Your Ref: 100659898-001
Our Ref: 24/00315/FULL

Application No: 24/00315/FULL
Proposal: Change of use from ancillary domestic store (Class 9) to short-term holiday let (Sui Generis) and replacement roof and formation of decking
Address: Forgehead Smithy Road Balmullo St Andrews Fife

LOCATION PLAN

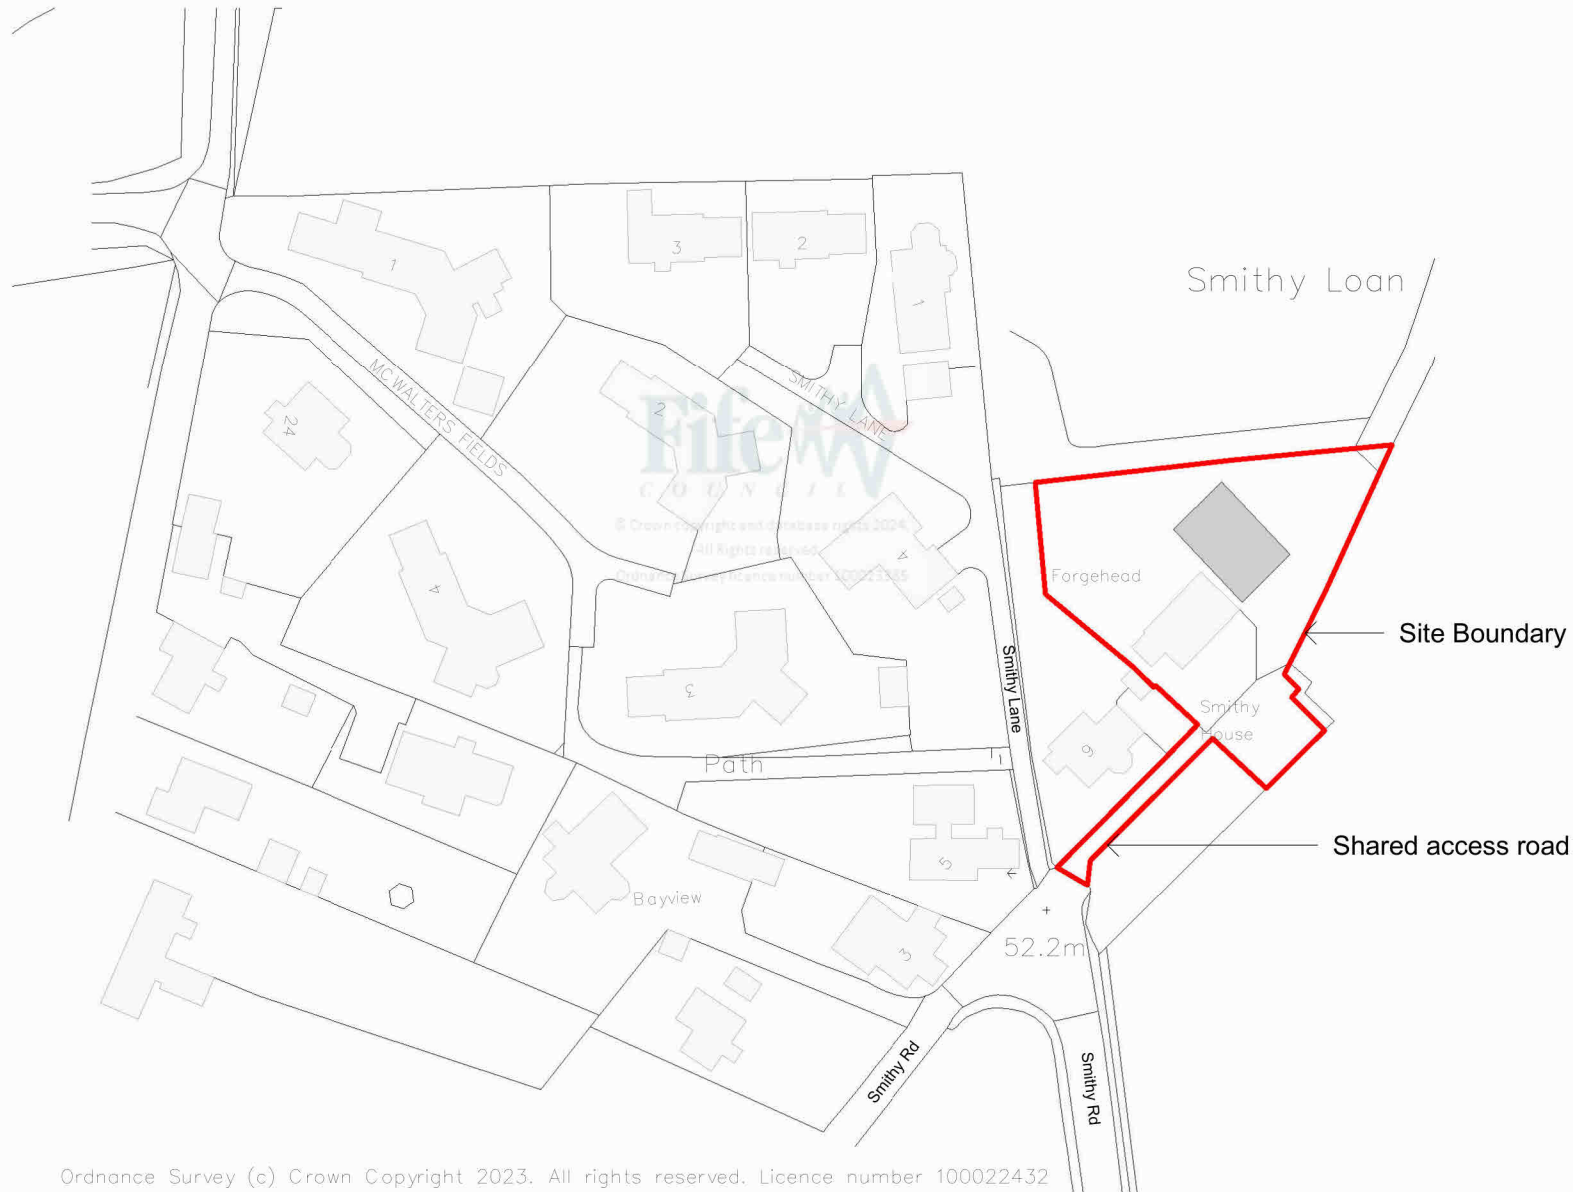
1. You have not submitted a valid location plan as it contains multiple red lines. We cannot accept the colour red on any other parts of the location plan and/or multiple red lines. Please submit a location plan to a scale of 1:2500 or 1:1250 with only the boundary of the site (including the access) to be developed clearly outlined in only one continuous red line showing a north point and at least two named roads and surrounding buildings. The purpose of the location plan is to ensure that the exact location of the application site is clear. Please also ensure the re-submitted location plan contains an appropriate Ordnance Survey licence/serial number and amend the Land Ownership Certificate if applicable.
